**EL PASO COUNTY PLANNING AND
 COMMUNITY DEVELOPMENT
 DEPARTMENT**

STORMWATER MANAGEMENT PLAN CHECKLIST

SHEET No. 4

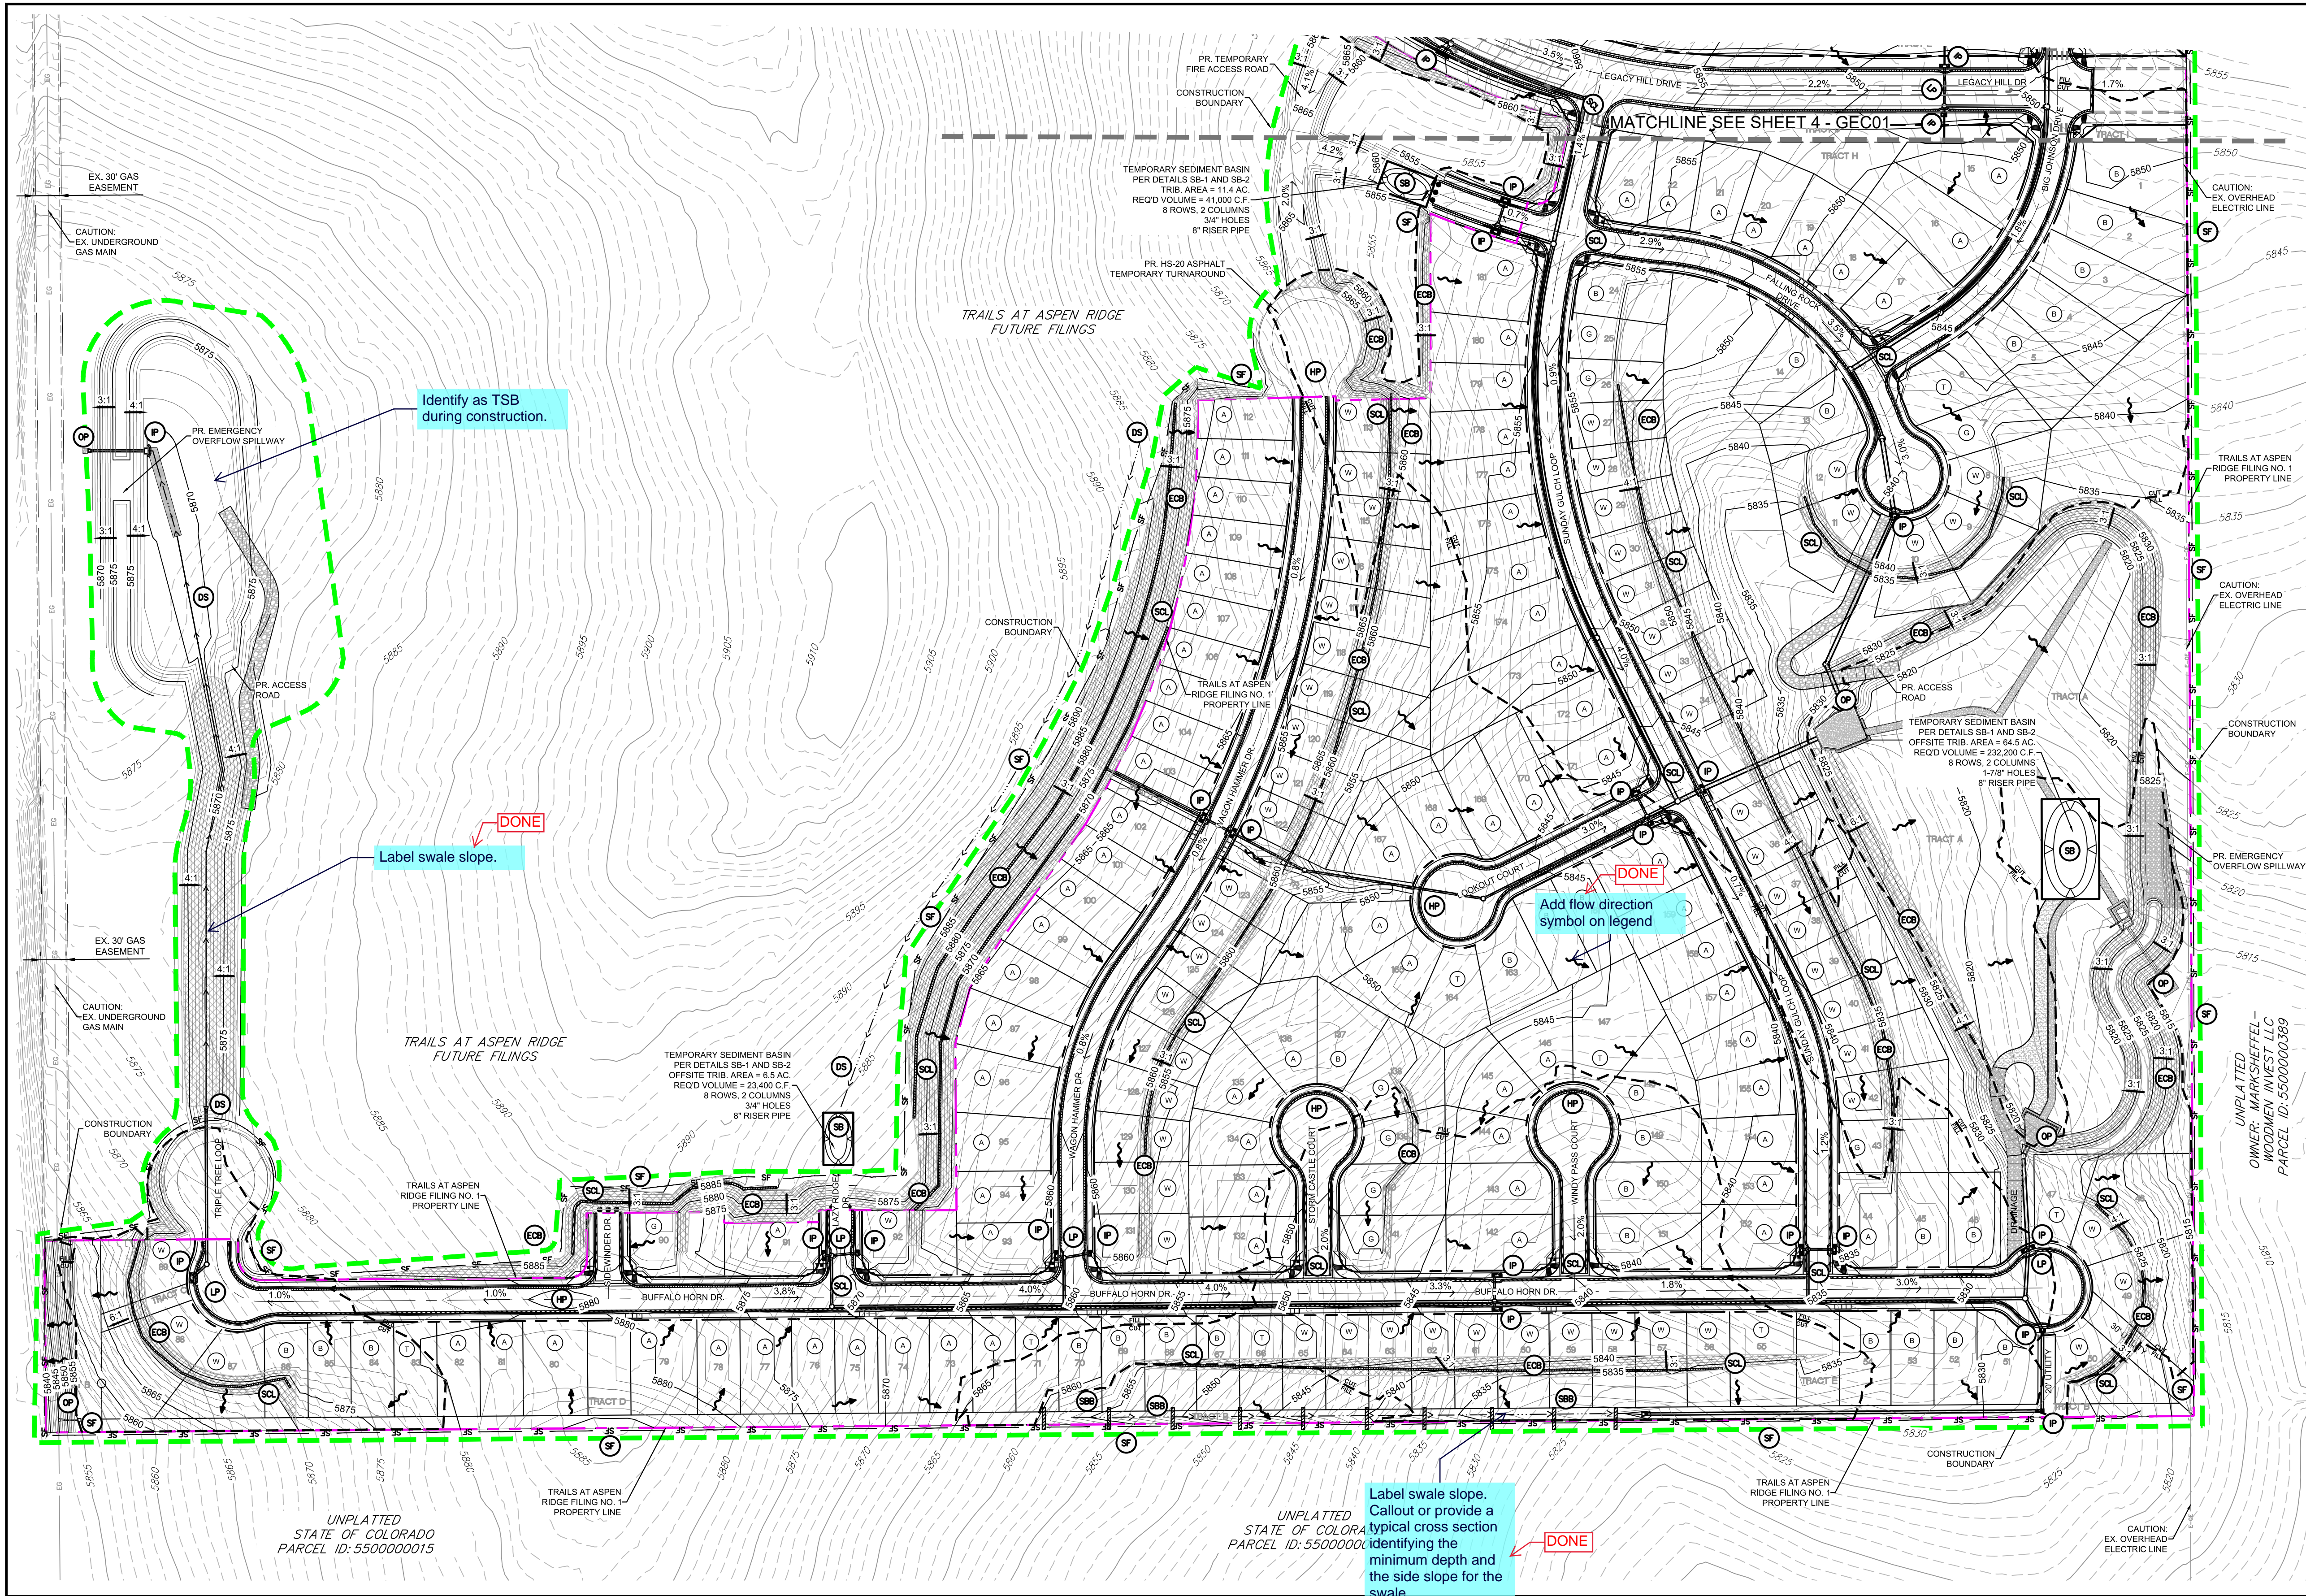
Update the narrative for the Erosion Control Blanket in Section 2 (pg 8) of the SWMP Report. It noted ECB is not used with this project. GEC Plans shows installation of ECBs.
